Re: State Significant Development (SSD 8865 Modification 4) - St Anthony Padua Catholic School

Attachment – Detailed comments

Figure 1: Waste storage area location on the ground floor

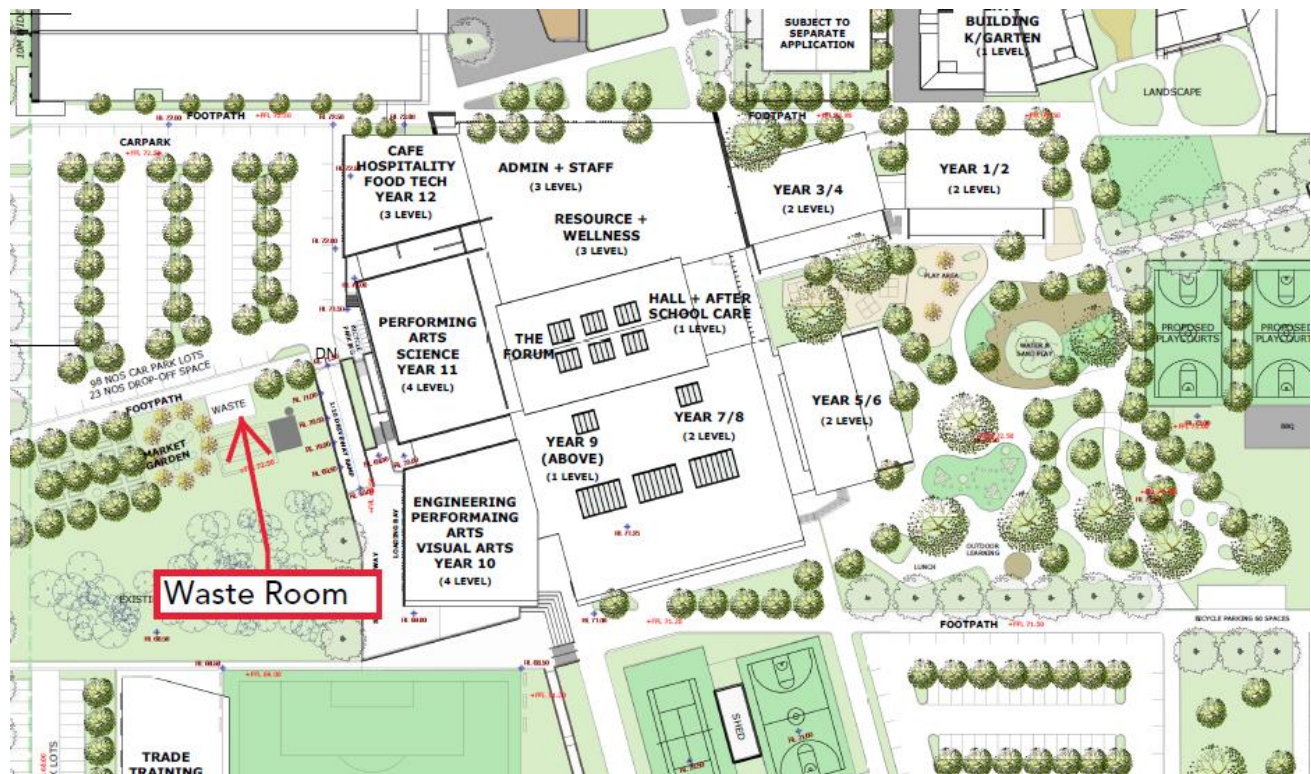
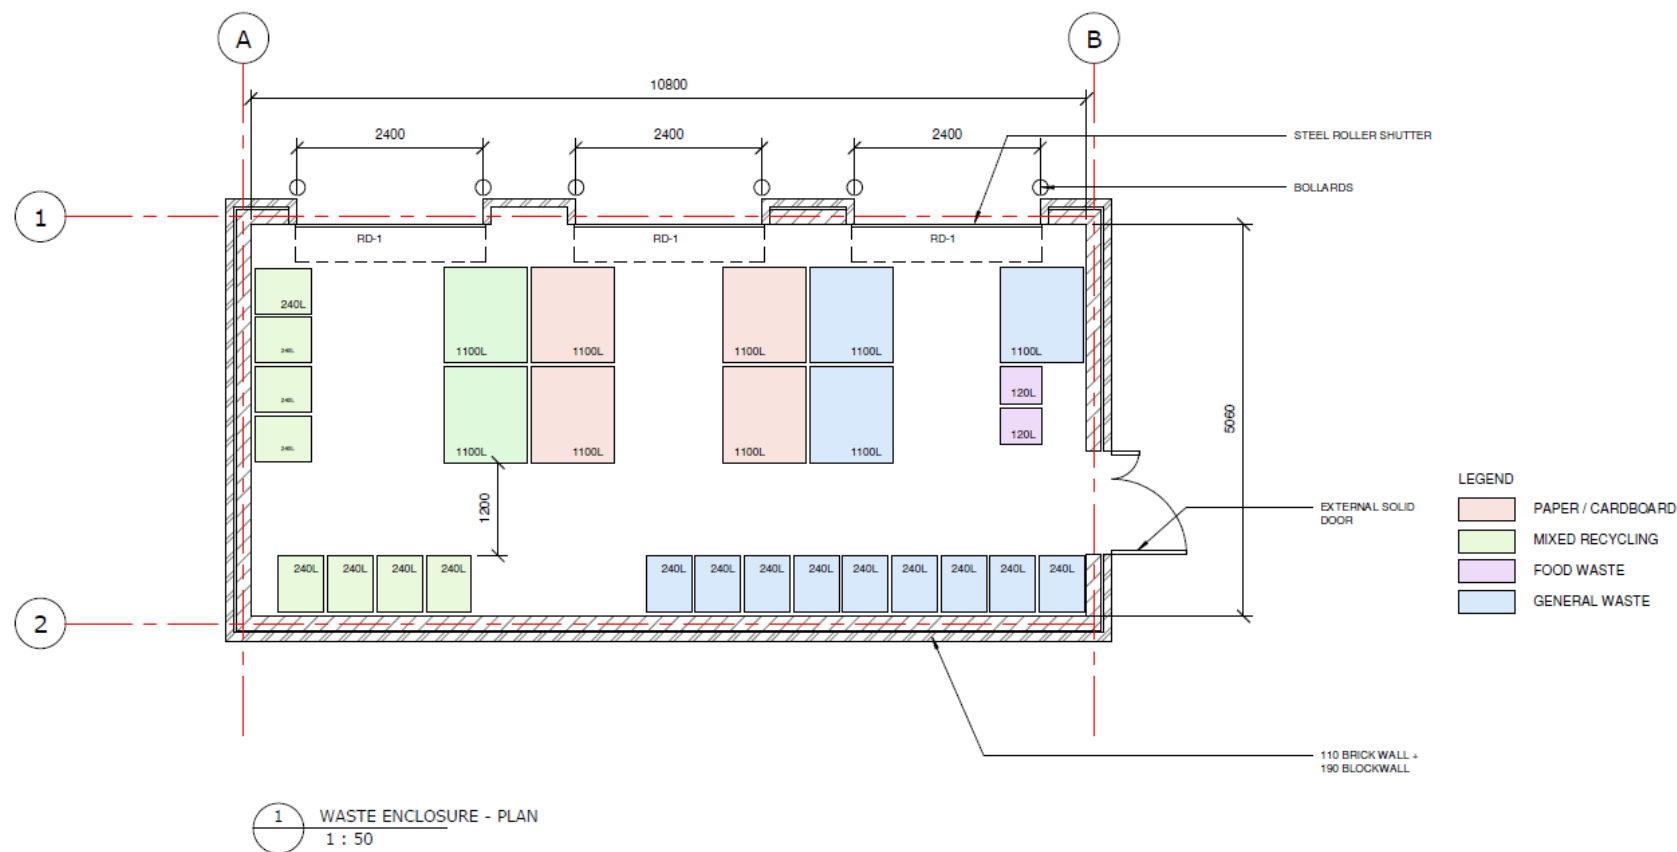
- The garbage/waste storage area shall be clearly identified on the site plan and be located within the proposed building. The designated garbage/waste storage area shall comply with the following requirements:
 - The room shall be fully enclosed and provided with a concrete floor, and with concrete or cement rendered walls coved to the floor;
 - The room shall have a floor waste which is to consist of a removable basket within a fixed basket arrestor and is to comply with Sydney Water requirements; and
 - The door to the room must be tight-fitting, self-closing and fitted with mechanical ventilation.
